Submission by G Webster & Son Ltd & Mr Rex Webster

Norwich to Tilbury

Deadline 1 Submission

Property: Flordon Hall Farm

Representation – Vision/Intrusion

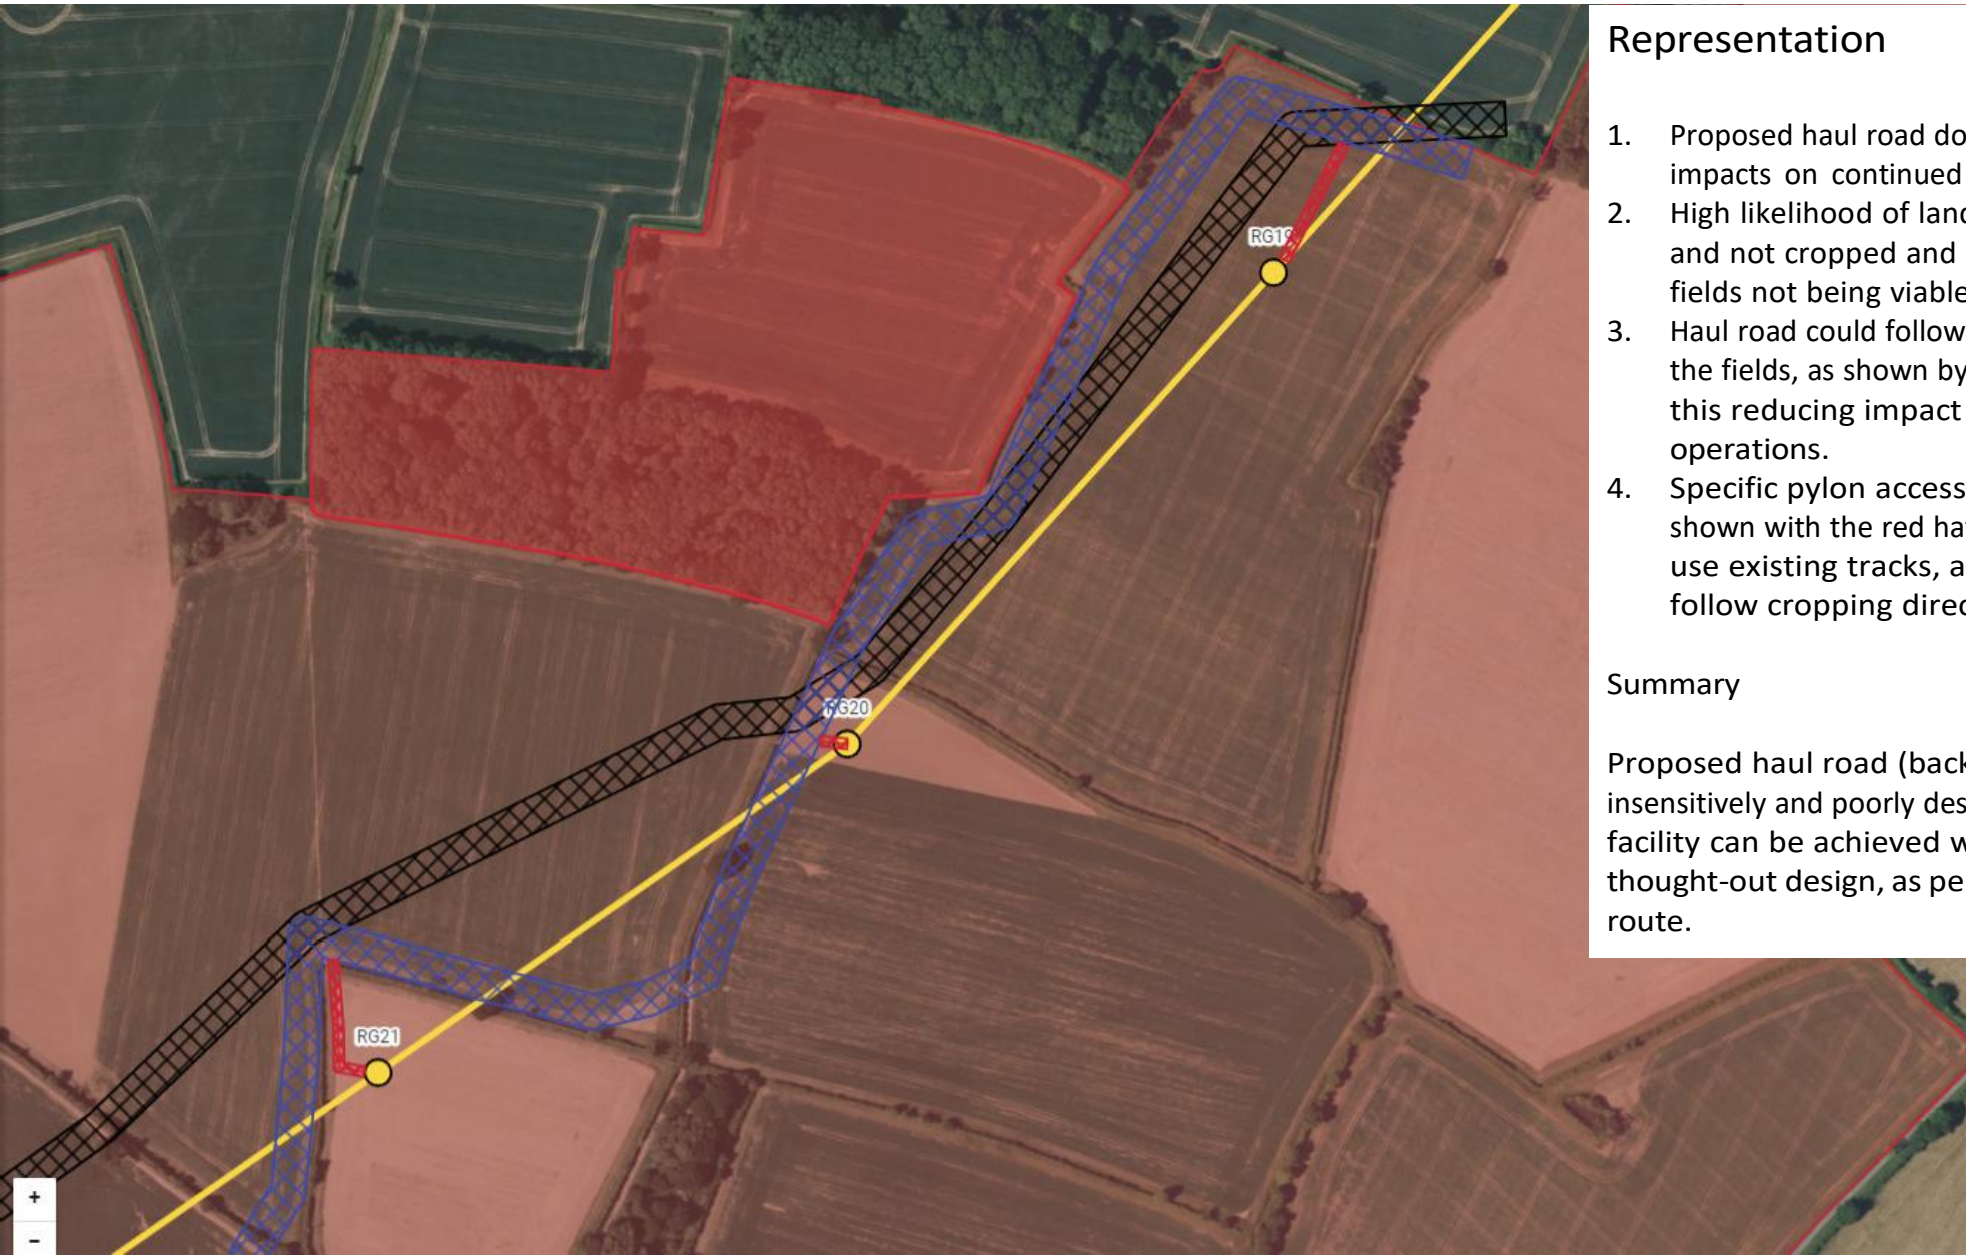
1. Flordon Hall (Yellow Area) – Grade II* Listed Building – Pylon line and pylons RG21 and RG22 highly visible from rear of Flordon Hall. The proposals impact the setting and character of Historically Important property, including the associated Grade II listed farm buildings.
2. Hall Cottages (Green Area) – impacted on front and rear-view splays, with 2 pylons on either primary face plus large spans of cable.
3. High Hopes (Blue Area) – severe impact to primary view and garden space. Cables within 200m, 1 pylon in direct line of sight, 1 pylon in the periphery view and 560m of cable span in direct sight.

New line impacts 6 dwellings and a range of farm buildings with development potential. Properties are impacted by overhead cable and 4 pylons.

RG22 and RG21 have most severe impact
 RG 20 and RG23 will impact the horizon
 Significant impact on an important Listed Building and overall setting.

Representation

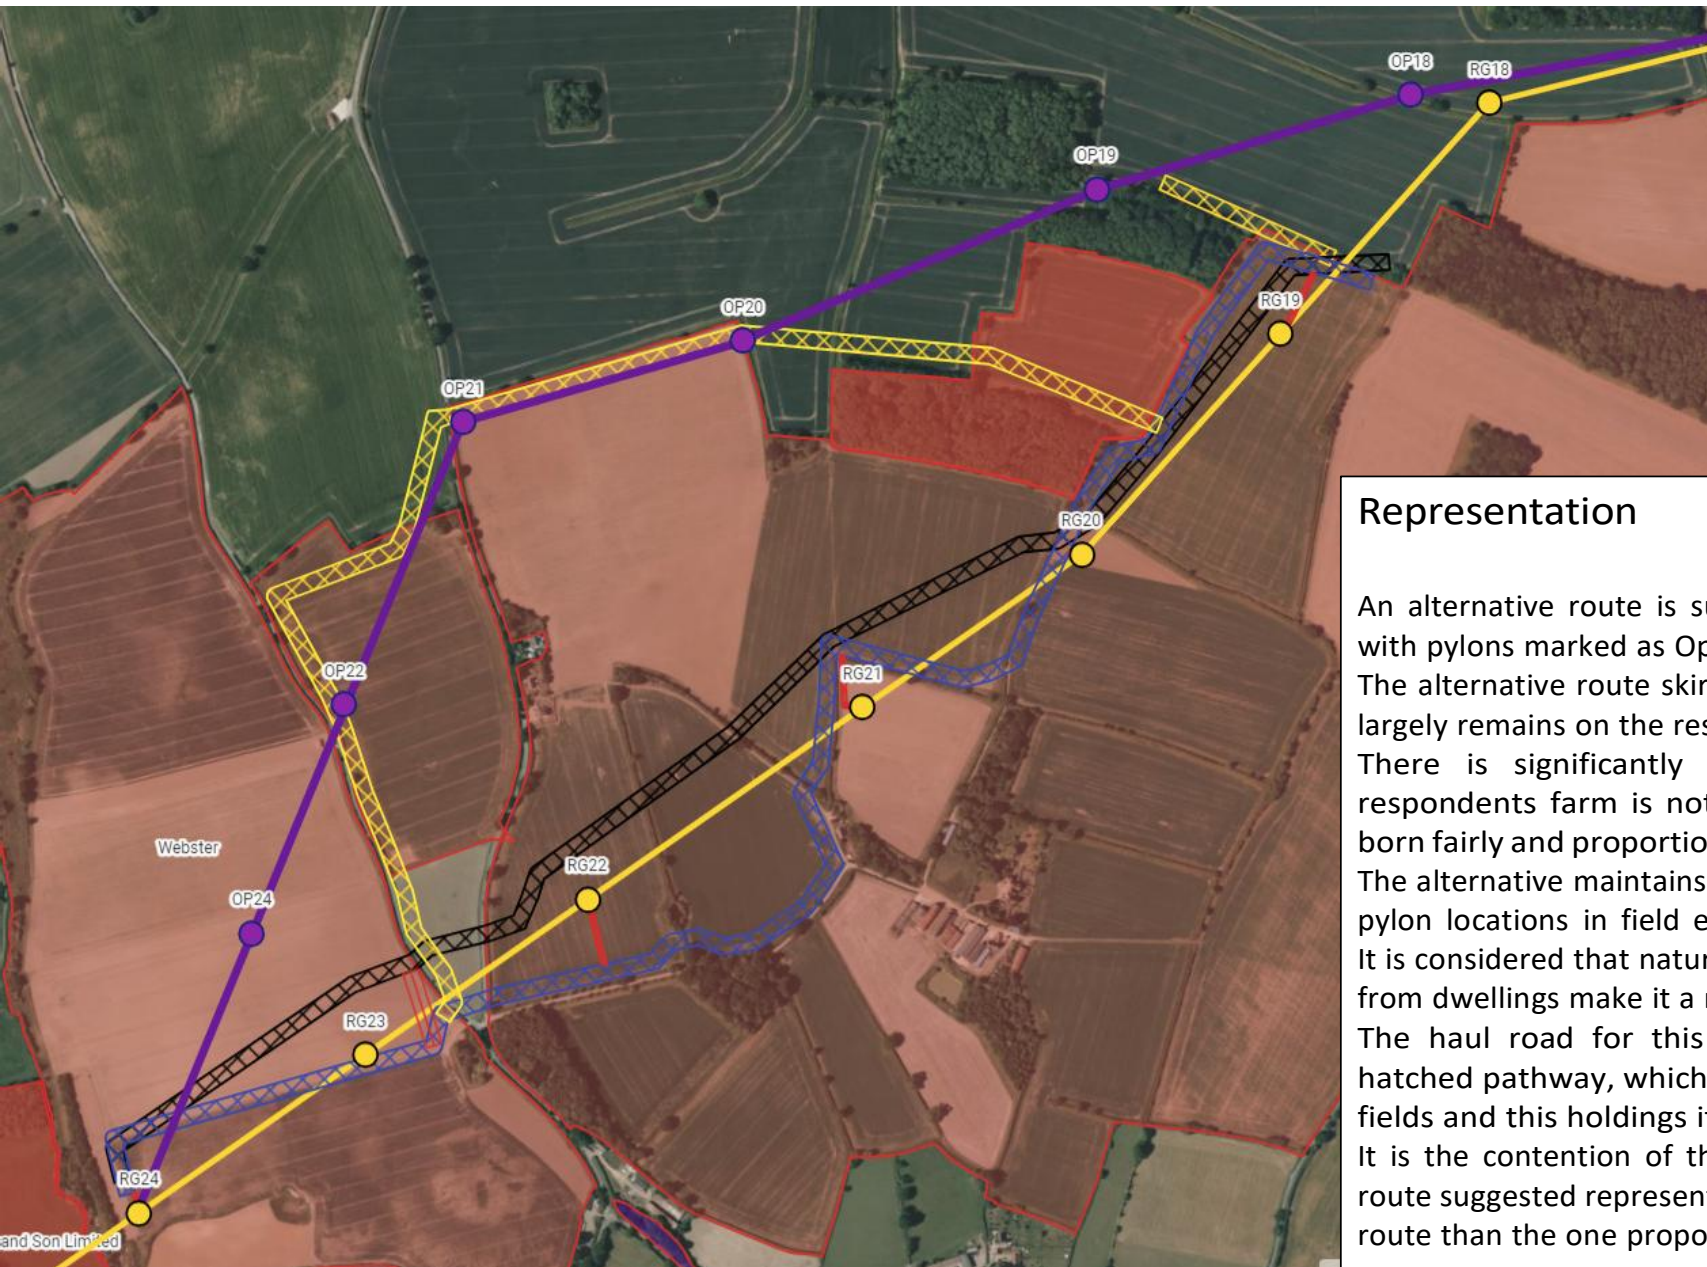
1. Proposed haul road does not mitigate impacts on continued use of the land
2. High likelihood of land being severed and not cropped and remainder of fields not being viable to crop
3. Haul road could follow the periphery of the fields, as shown by the blue option, this reducing impact on farming operations.
4. Specific pylon access options are shown with the red hatched lines which use existing tracks, access points and follow cropping directions.

Proposed haul road (back hatch) is insensitively and poorly designed. The same facility can be achieved with a better thought-out design, as per the blue hatched route.

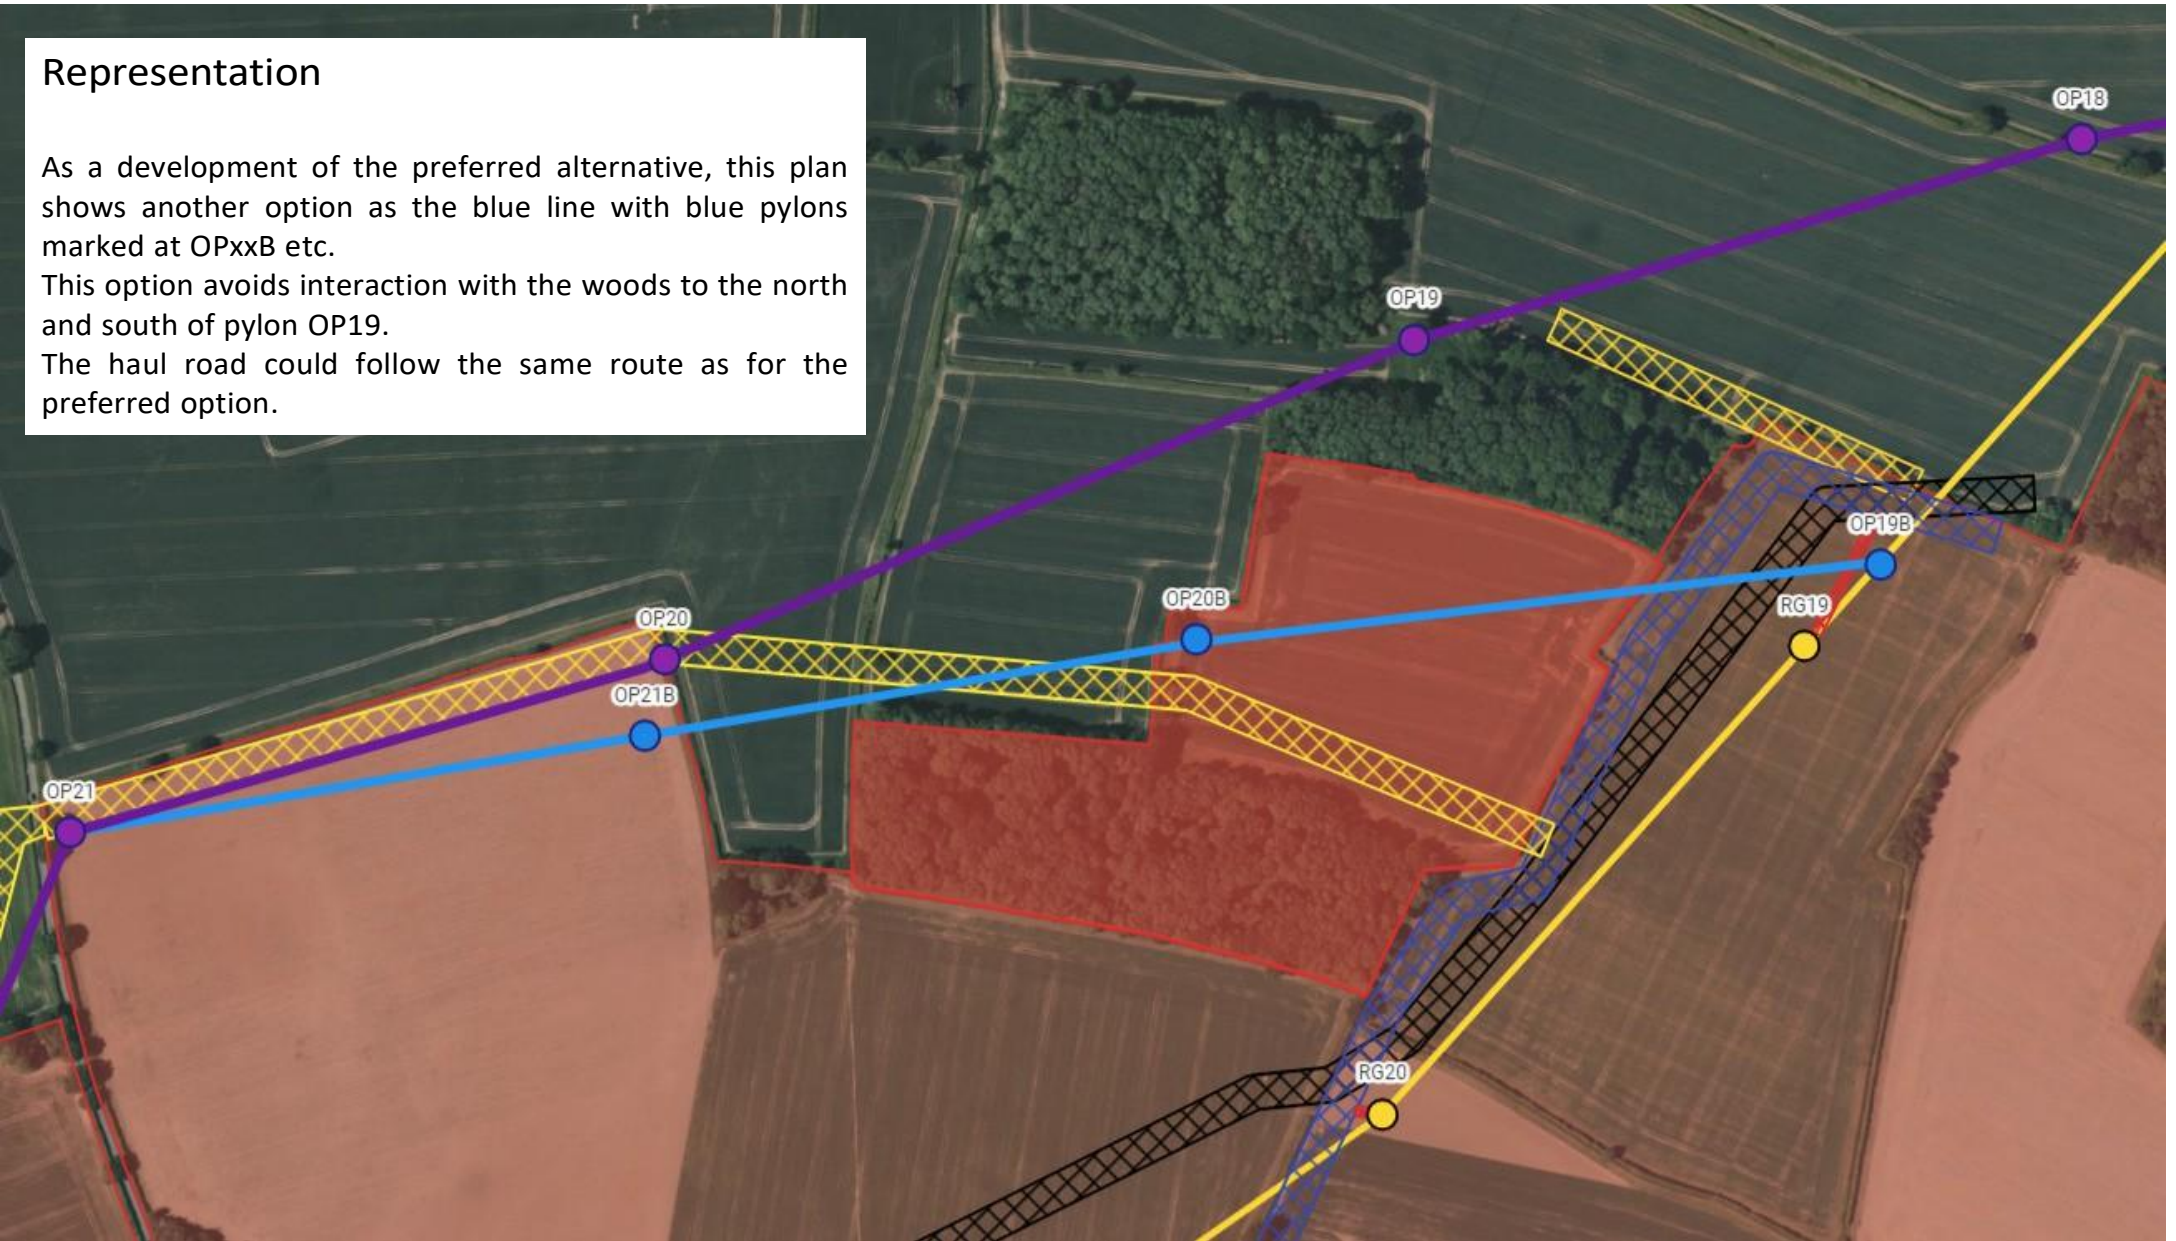
An alternative route is suggested to follow the purple line with pylons marked as Opxx. The alternative route skirts the edge of two ownerships but largely remains on the respondent's property. There is significantly less impact on dwellings, the respondents farm is not bisected and the burden is still born fairly and proportionally between landowners. The alternative maintains a primarily straight route, offers pylon locations in field edges and well screened positions. It is considered that natural screening, terrain and distance from dwellings make it a more suitable route. The haul road for this option is shown as the yellow hatched pathway, which again can follow the periphery of fields and this holdings it crosses. It is the contention of the respondent that the alternative route suggested represents a more balanced and reasonable route than the one proposed.

Representation

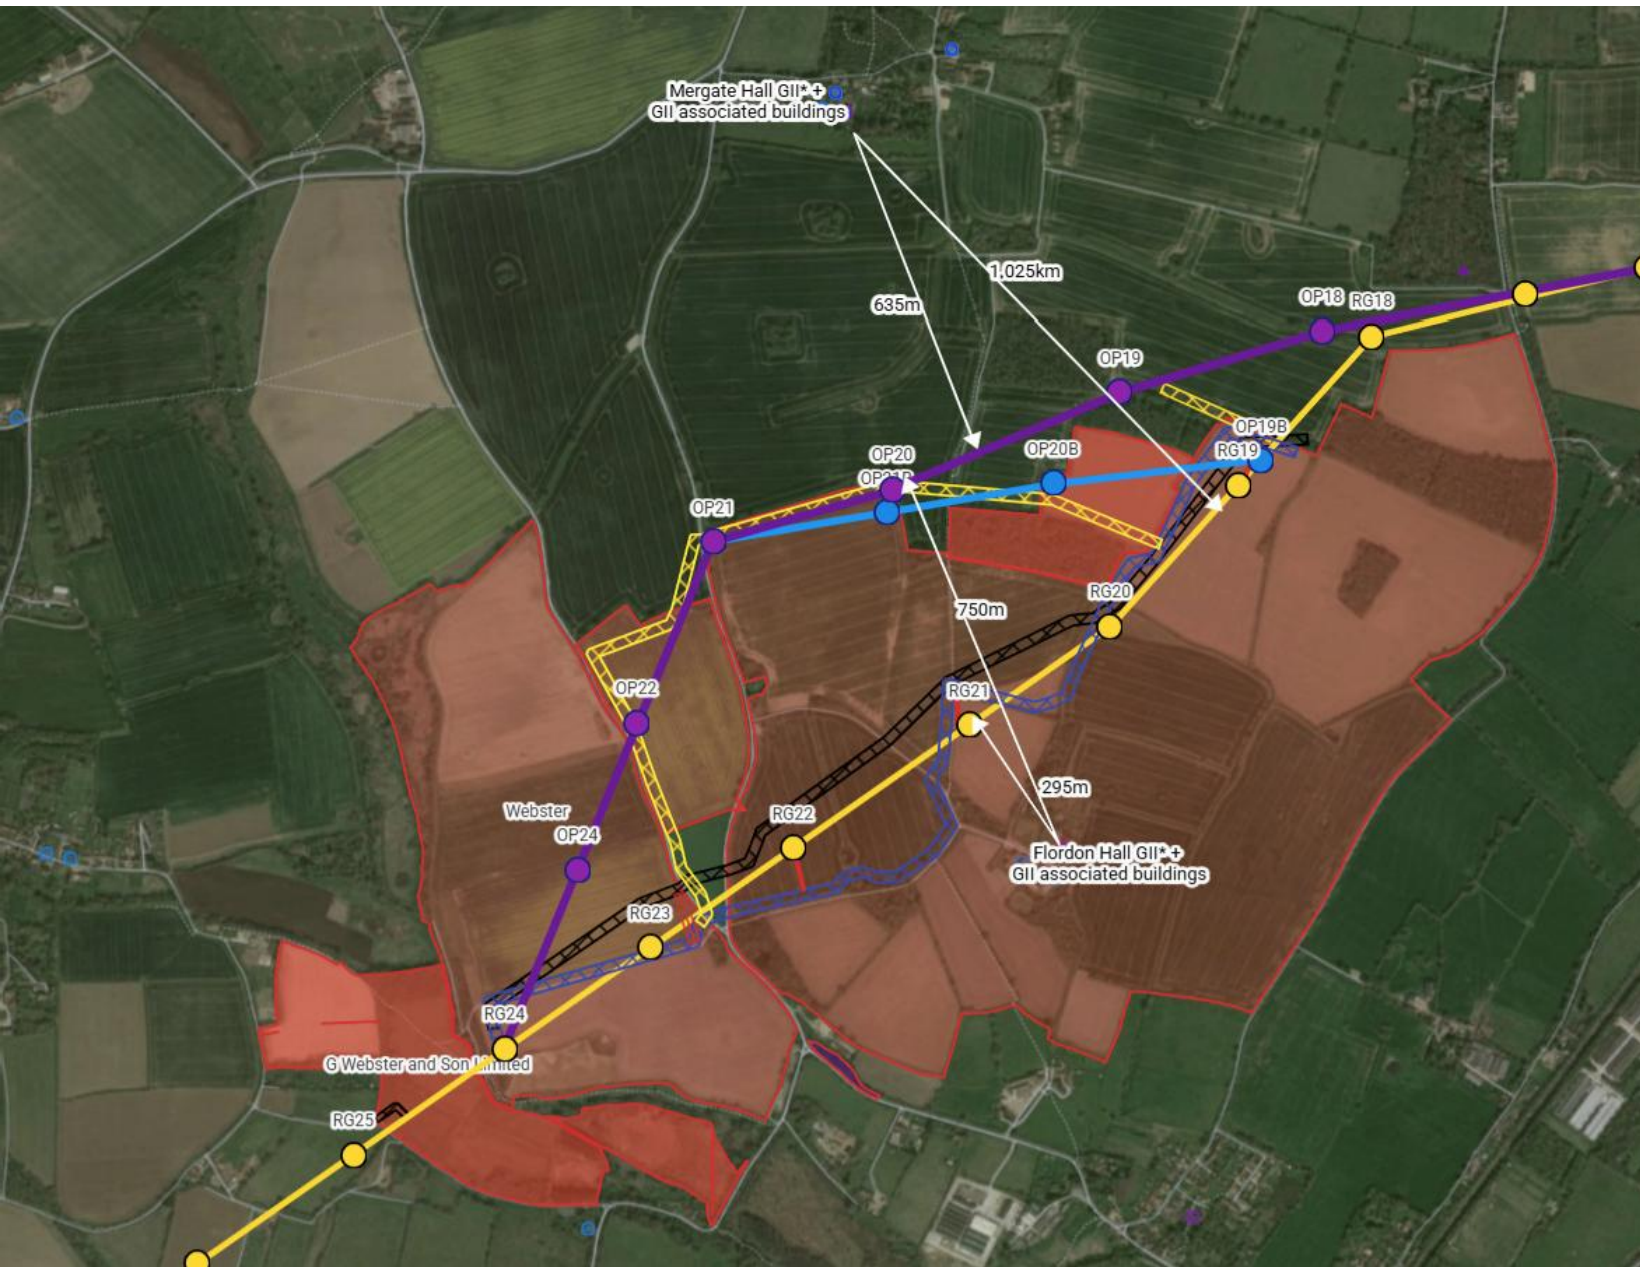
As a development of the preferred alternative, this plan shows another option as the blue line with blue pylons marked at OPxxB etc.

This option avoids interaction with the woods to the north and south of pylon OP19.

The haul road could follow the same route as for the preferred option.
